Response to Planning Application

Application ref: LU/246/24/PL

Description: Demolition of existing structures and development of land to create 10 No. residential dwellings, landscaping, access, car parking and cycle parking. This application may affect the setting of listed buildings, is in CIL zone 2 and is CIL liable as new dwellings.

Location: Land at Toddington Lane Littlehampton BN17 7PN

Landscaping Strategy

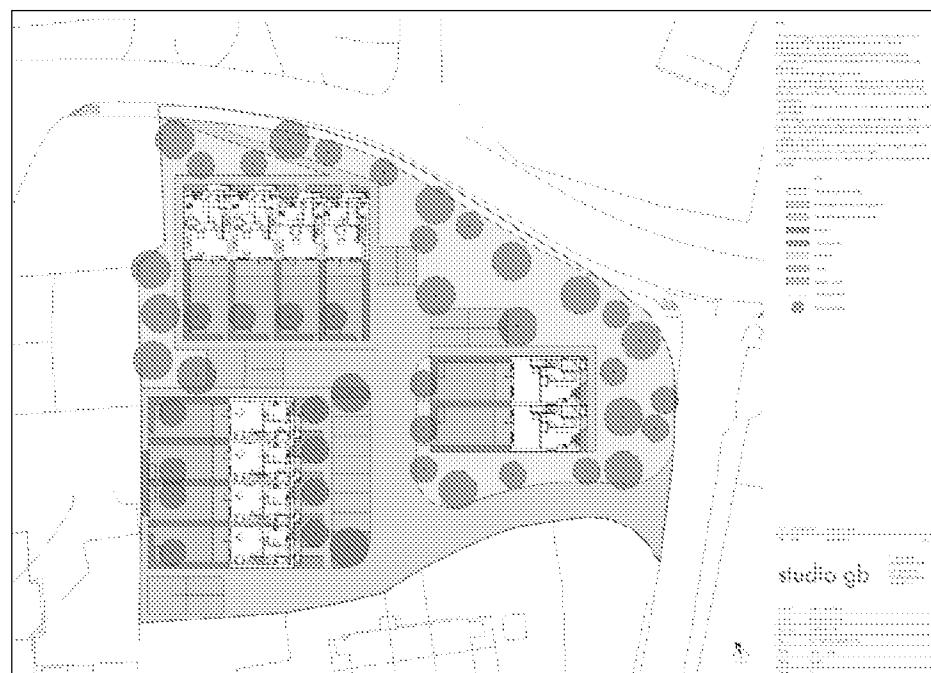
A site plan, Landscape GA L-101, Planting strategy, Landscape Statement and Design and Access statement have been submitted. The detail provided within these drawings is indicative only and would require further landscape drawings to detail actual quantities, planting densities and size at time of planting.

It is noted that much of the green infrastructure proposed is located within private garden locations, with trees and hedges which have the potential to be removed by the residents and therefore not a guaranteed long stay of the scheme. This in turn will effect Biodiversity Net Gain calculations. Green infrastructure proposals should be included within the site outside of private dwelling remits.

The landscape scheme submitted within the DAS is indicative only and will require plan submission of proposals to include quantities, species choice, position, densities and size at time of planting. This detail is required in plan and list form and in relation to existing trees and vegetation retained in order to given a clear and adequate picture of the proposals..
